**Consultation Response from KC,
Highways Development Management****2024/91243 Land at Nabbs Lane, Slaithwaite, Huddersfield, HD7 5AU****Erection of one dwelling (within a Conservation Area)****Date Responded: 20/06/2024****Responding Officer: CNB****Responding Ref: K1-33/17**

Drawing	Scale @ A1
Proposed Site Plan	1:100
Drawing No. 3594 (0-) 10	Revision -

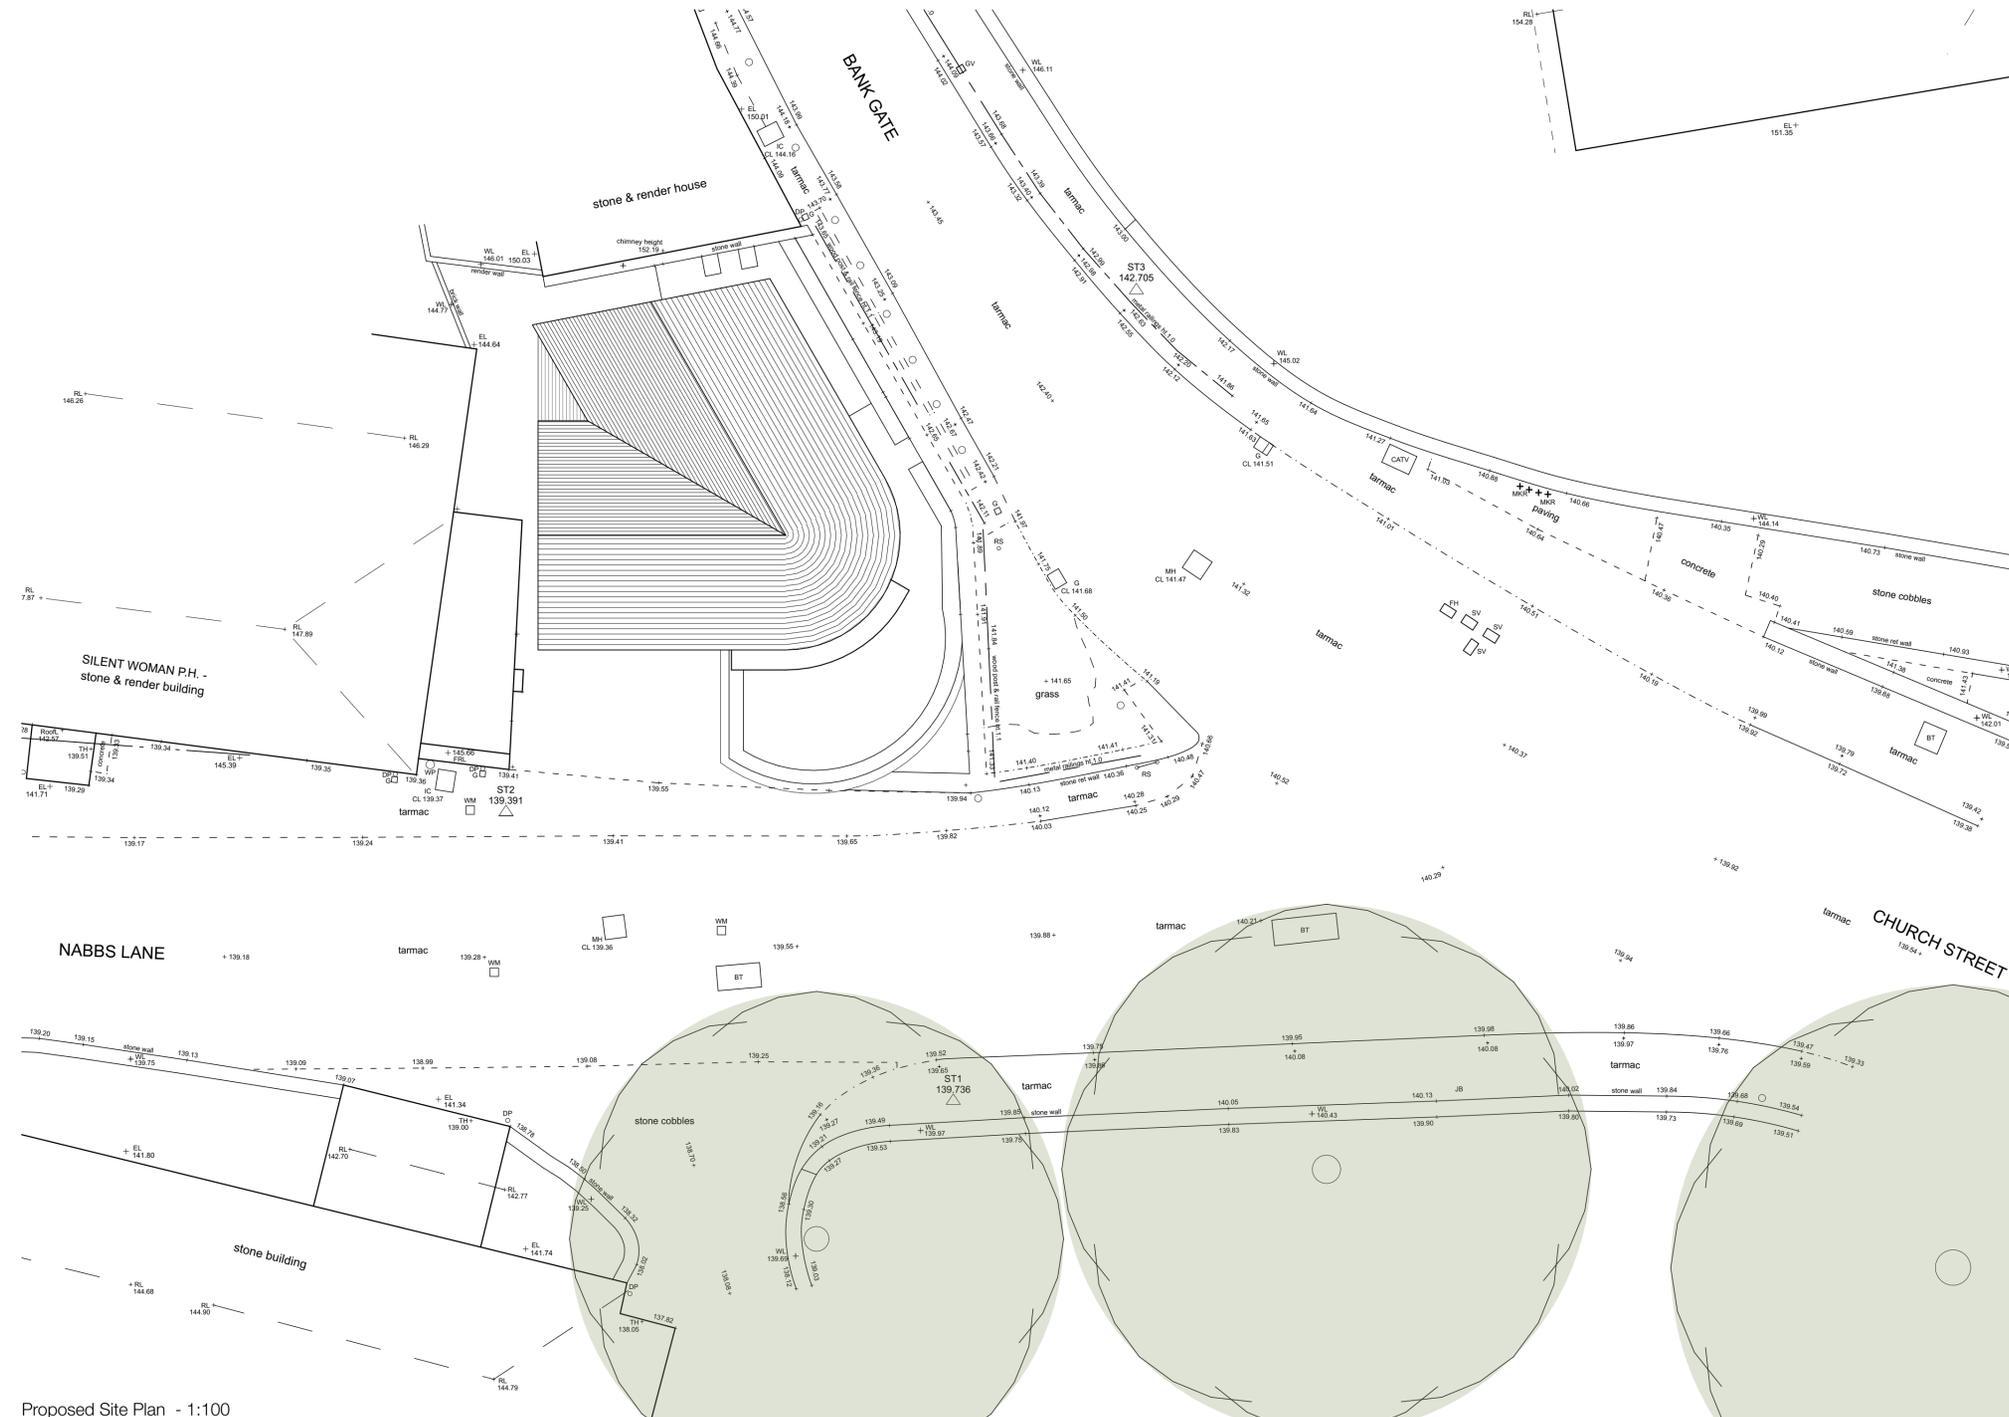
With the previous outline applications, visibility splays for the new access were requested and these should be provided as part of the current application. For a 30mph road the visibility splay measurements should be a minimum of 2.4m x 43m unless speed survey data is provided as evidence that the 85th percentile speeds are lower than 30mph, in which case the visibility splay y-length can be adjusted accordingly. The visibility splays should be clearly indicated on a drawing and submitted to the LPA for written approval and this should be conditioned.

The visibility splay to the left would only need to extend as far as the junction with Church Street, however we do not think this would be achievable due to the proposed build out of the dwelling to house bedroom three and we consider that if this aspect of the design can be moved back away from the rear of the adopted highway sufficiently, then this visibility splay should be achievable.

An easement strip of not less than 2.0m wide shall be retained between the proposed building and the existing private retaining wall supporting Bank Gate to facilitate access for its future inspection and maintenance, unless if the proposed building wall directly abuts Bank Gate and is designed to accommodate the required highway loading.

Prior to the development being brought into use, the sightlines of 2.4m x 43m along Nabbs Lane shall be shown on a plan and presented to the local planning authority for written approval and afterward these visibility splays be cleared of all obstructions to visibility exceeding 0.9 m in height and these shall be retained free of any such obstruction throughout the lifetime of the development. If speed survey data can be provided to show evidence that the 85th percentile road speeds are below the posted road speed of 30mph, then the visibility splay y-lengths can be adjusted appropriately based on calculations contained in table 7.1 of manual for Streets.

Drawing No.  
**3594 (0-) 09**  
 Revision  
 -

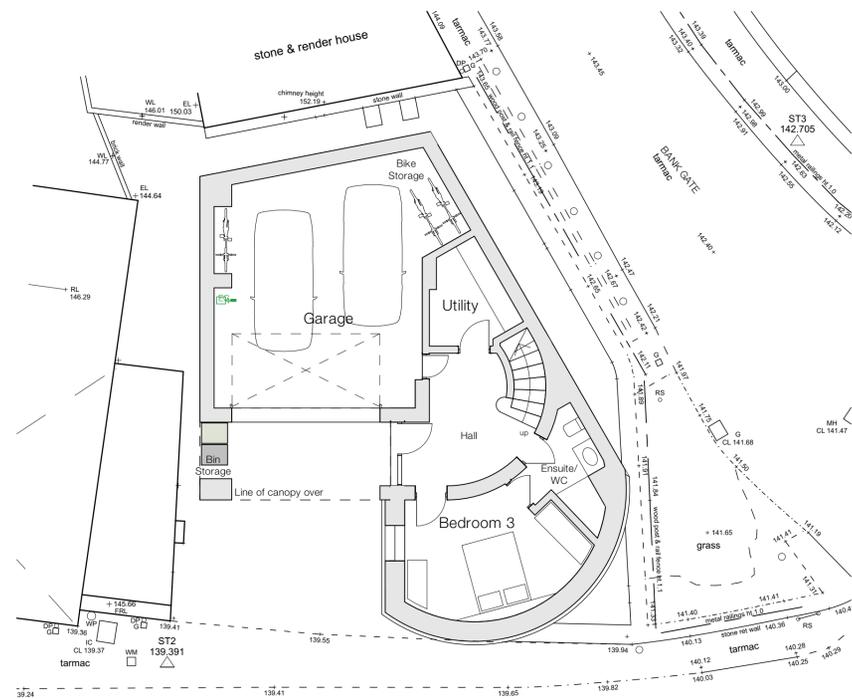
The proposed dwelling is to have 3-bedrooms and for a development of this type and size there would be a requirement for 2 off-street parking spaces to accord with local guidance. These parking spaces are

indicated on drawing No 09 within an integral double garage with internal measurements of 6.3m x 5.5m and this would be acceptable for two parking spaces. The garage also includes space for cycle storage. There is also a driveway of approximately 6m deep x 5m wide and this would be suitable for a single car parking space and still allow for pedestrian access to the site and storage for waste and recycling bins.

Drawing No 09 also indicates the location of a bin store located approximately 6m from the rear of the adopted footway. There also appears to be suitable space within the driveway for a bin collection presentation point at the rear of the footway without obstructing access to the parking spaces, and this is acceptable.
